CITY OF ALBUQUERQUE

January 30, 2014

**Re: Drainage Master Plan and Grading Plan for Del Webb Phase 1 and 2
Engineer's Stamp Date –no stamp (H09D017C)**

CITY PROJECT NO. ZONE MAP NO. SHEET 2 OF 8

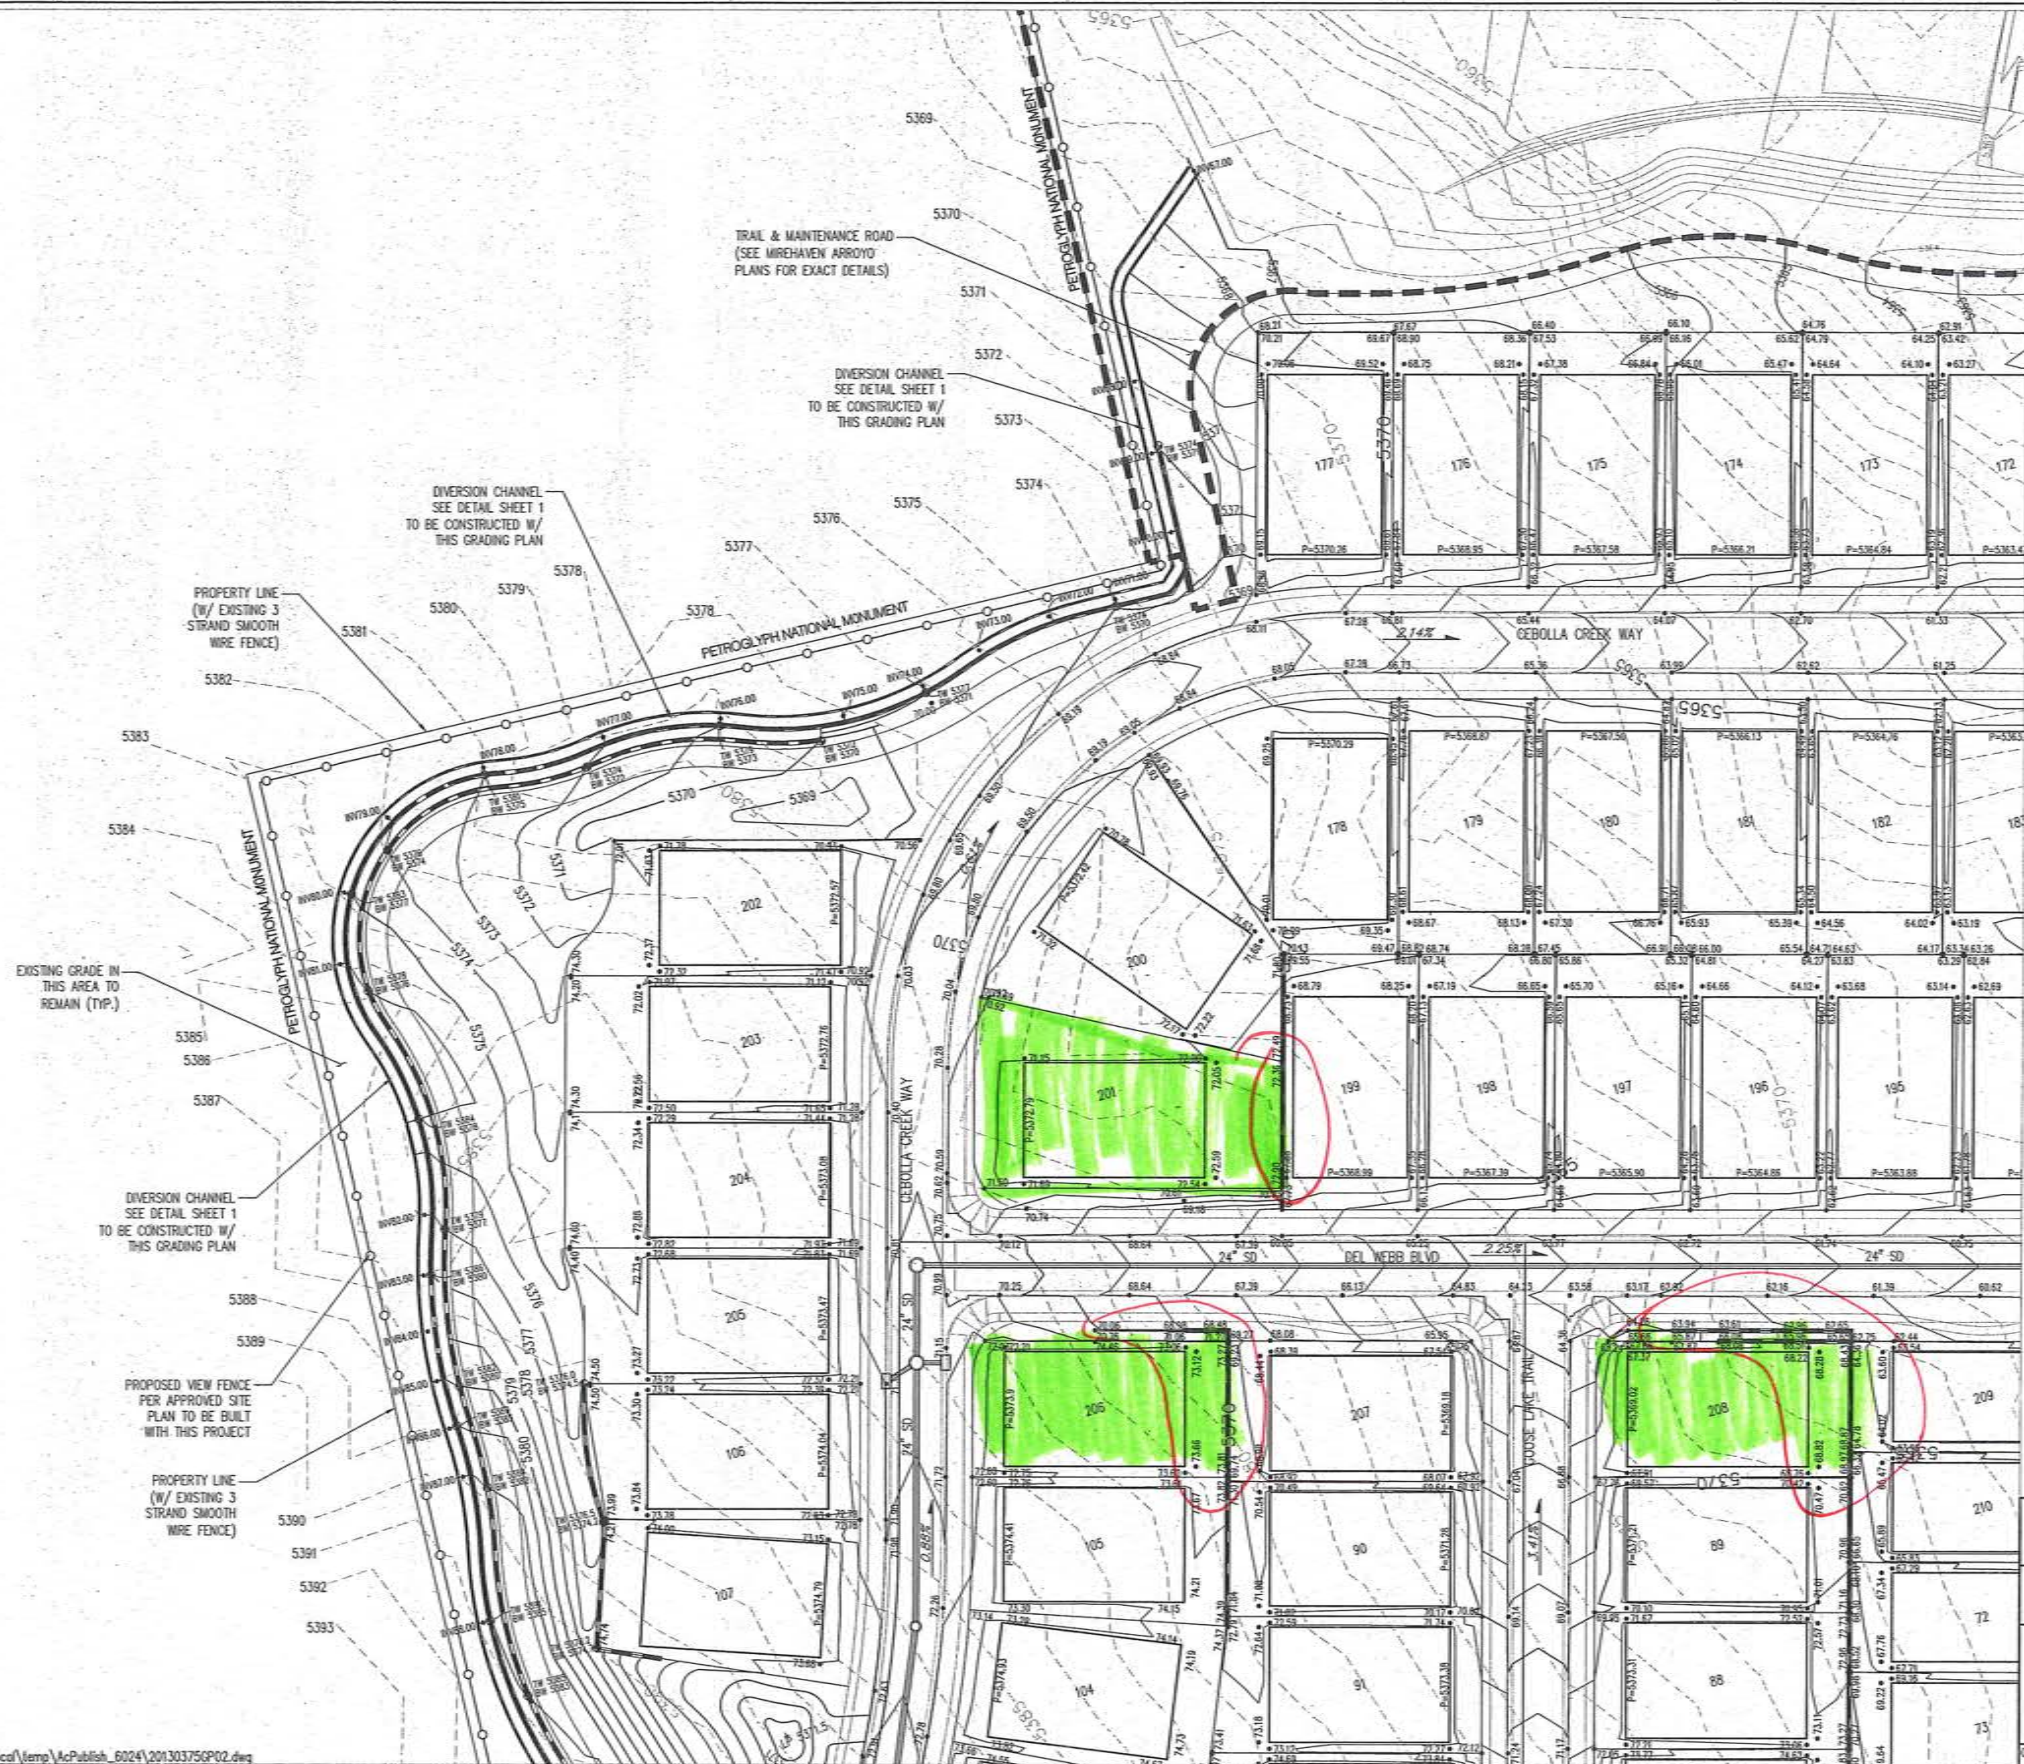
12. On Sheet 2 and 8 it is not apparent the grading plan is in compliance with the approved Site Plan for Subdivision concerning grading and walls near the monument boundary. Provide sections that are in the same locations as Sections 1 through 4 on the Site Plan for Subdivision.

13. Show the 5' wide channel on Sheet 2 with inverts.
14. Show the property line where this project abuts the monument and the grading perimeter.
15. 5 foot contours labels and contour lines should be bolder than the 1 foot labels and contour lines.

DESIGN REVIEW COMMITTEE	CITY ENGINEER APPROVAL	LAST DESIGN UPDATE	MO./DAY/YR.	MO./DAY/YR.	
CITY PROJECT NO.	ZONE MAP NO.	SHEET	8	OF	8

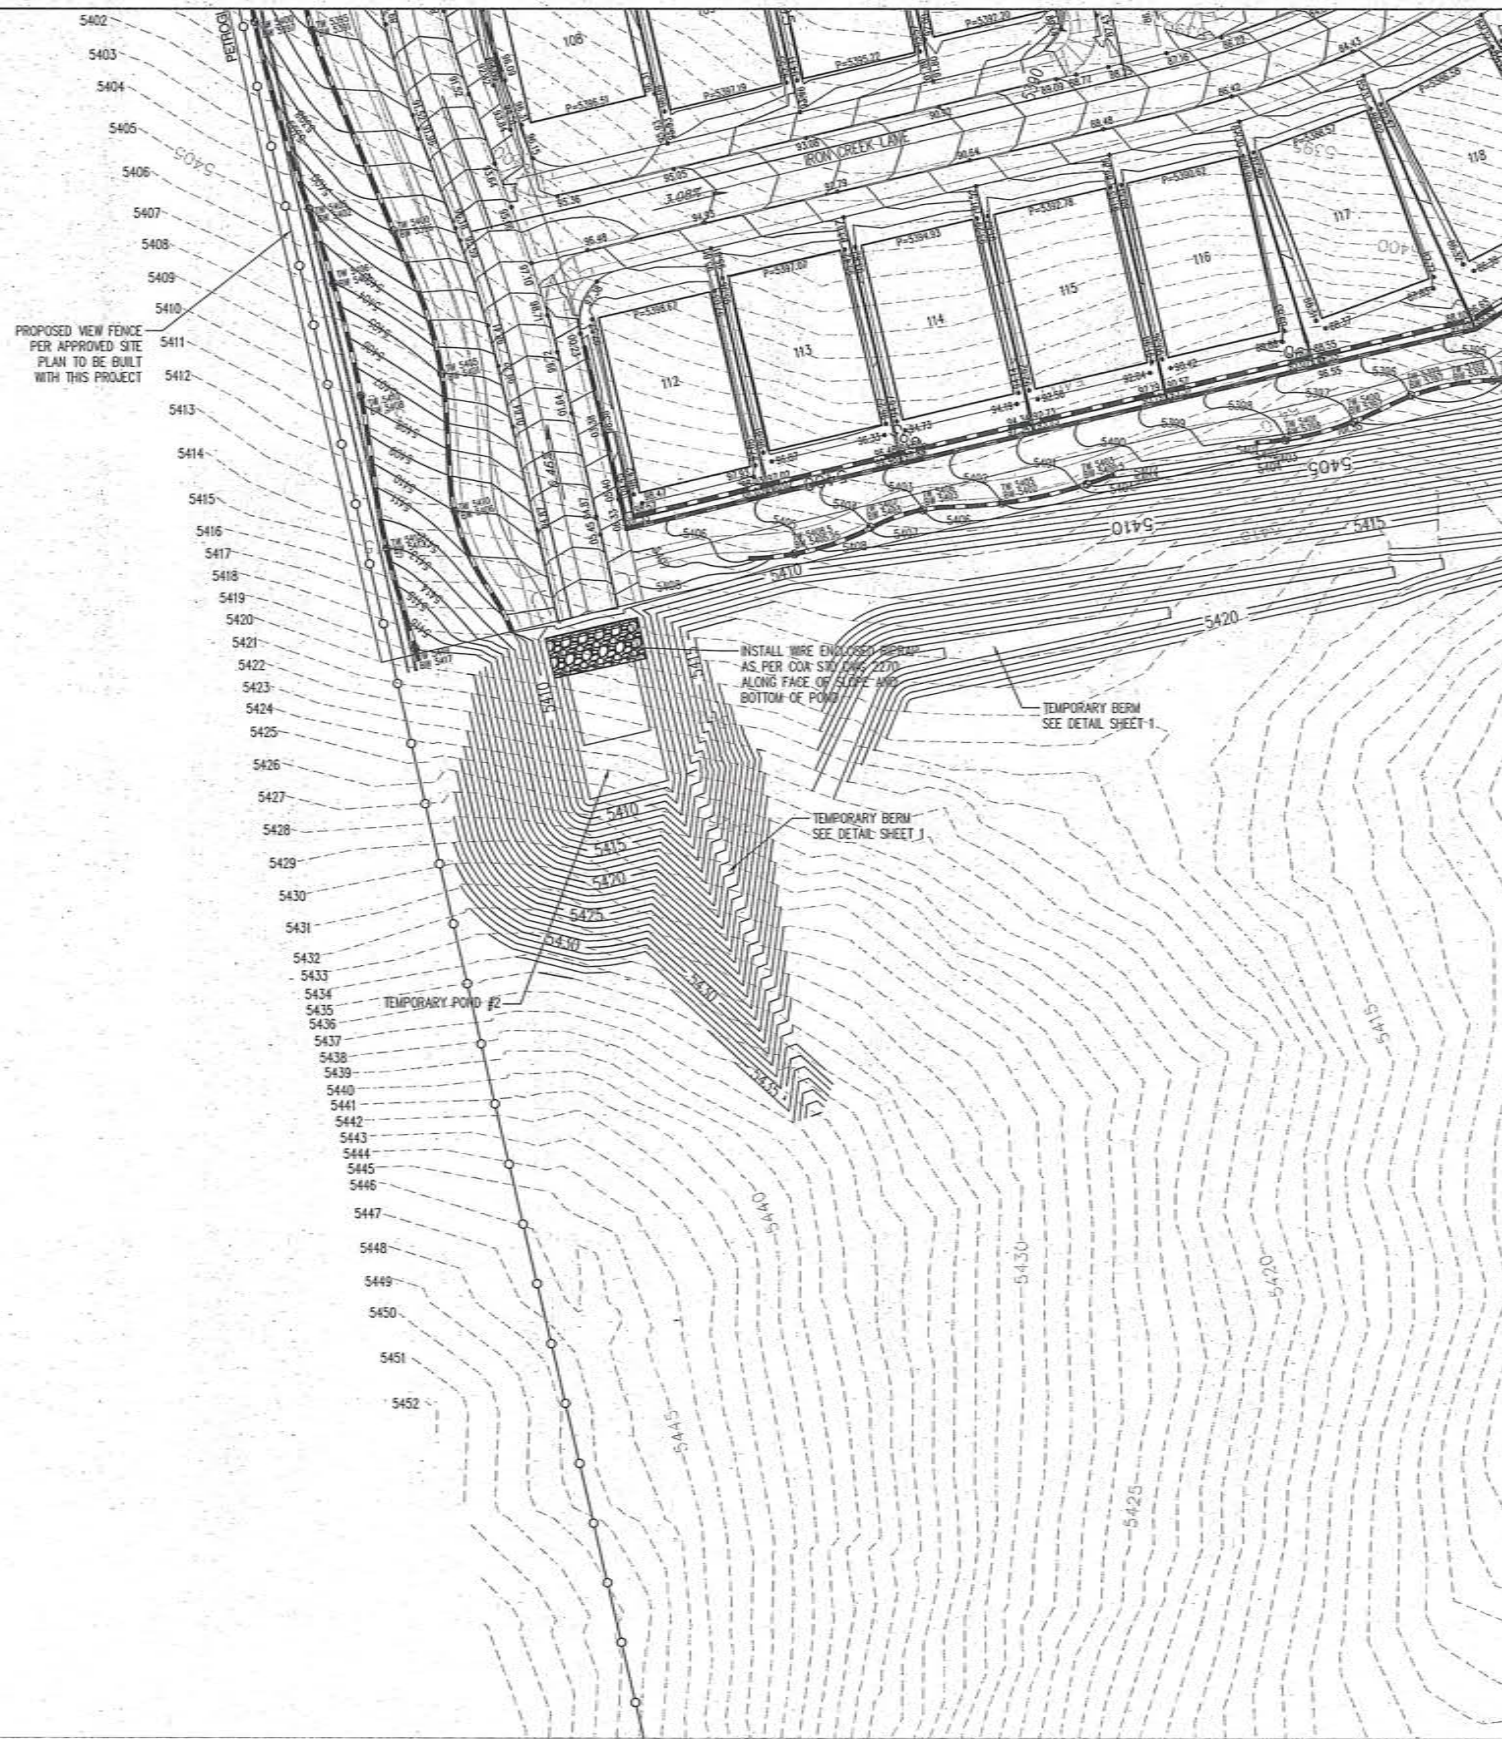
16. On Sheet 8, provide grades so it is evident the pond at the end of Cebola Creek Way is a pond. Include the required volume from the drainage report and label the pond.

17. It appears a culvert should be proposed under the trail in the break in the retaining wall on Sheet 8 and Sheet 6.
18. Show the storm drain and inlets on the grading plan.
